Recommendation Report for Planning Permission

REF NO: LU/109/26/PL

LOCATION: 17 Ernest Fitches Way
Littlehampton
BN17 7EP

PROPOSAL: Erection of a single-storey timber garden cabin to be used as a small-scale dog grooming business ancillary to the main dwelling.

Block plan - 17 Ernest Fitches Way

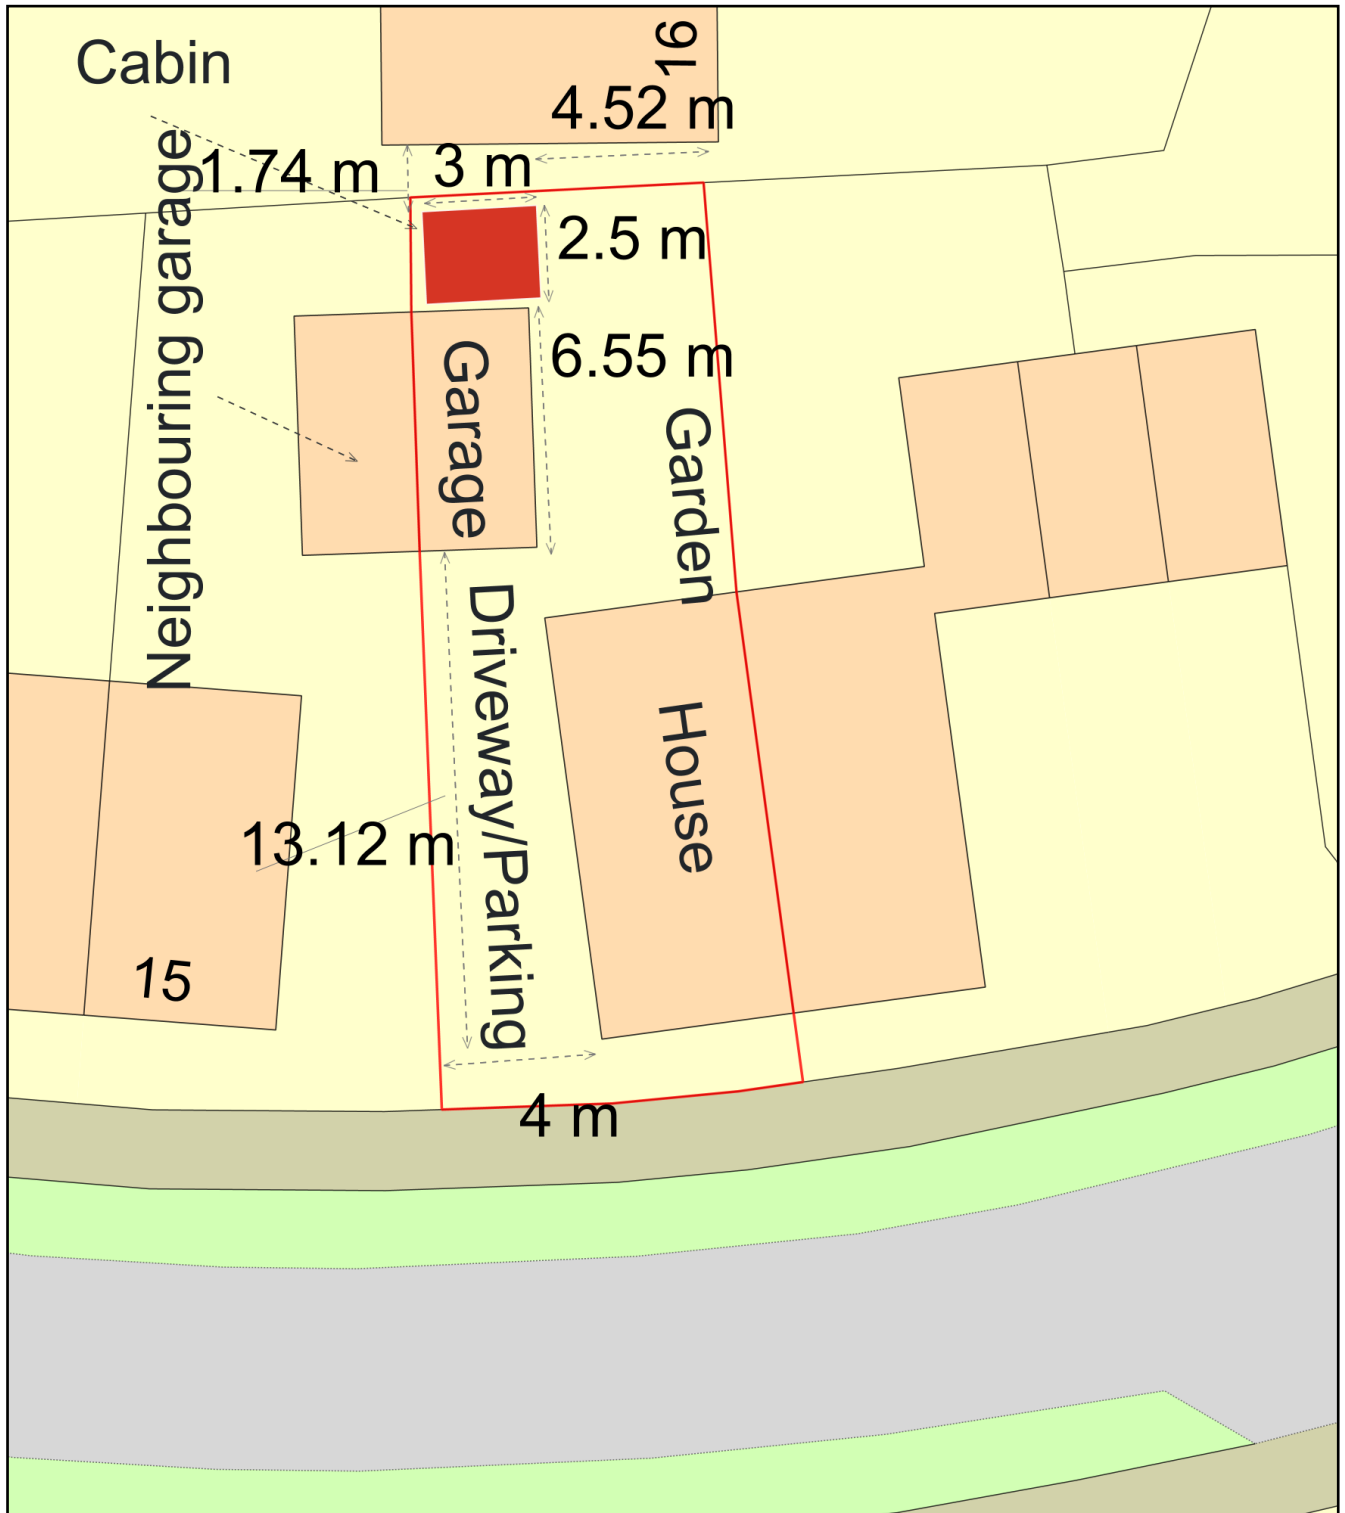
The outbuilding would be to the rear of the existing detached garage, and would be adjacent to the rear boundary of the property. The outbuilding would measure approx. 2.3m by 3.2m and would have a

The site is a semi-detached house, with neighbours to either side. The property's neighbour to the rear is arranged perpendicularly to the property, with the side elevation of the property running alongside the site's rear boundary. The separation distance between the rear neighbour and the outbuilding would be 1.7m.

The height of the outbuilding is modest and reflects a typical small ancillary building. The building is to the rear of the garage and would not result in significant additional overbearing or overshadowing impacts on the property's neighbour to the east. The property to the rear has no windows on its southern elevation, and the building would not result in any loss of outlook. The structure itself would be considered permitted development under Class E of the General Permitted Development Order 2015 (GPDO), and the outbuilding would not result in adverse impacts by way of overbearing, overshadowing or overlooking in accordance with ALP policy D DM1.

The dwelling provides three parking spaces, all of which will be retained by the development. With only one dog allowed in the outbuilding at one time, the increase in car numbers within the area will be minimal, and of little harm to highway amenity. As such, the parking spaces retained are sufficient for the proposed use.
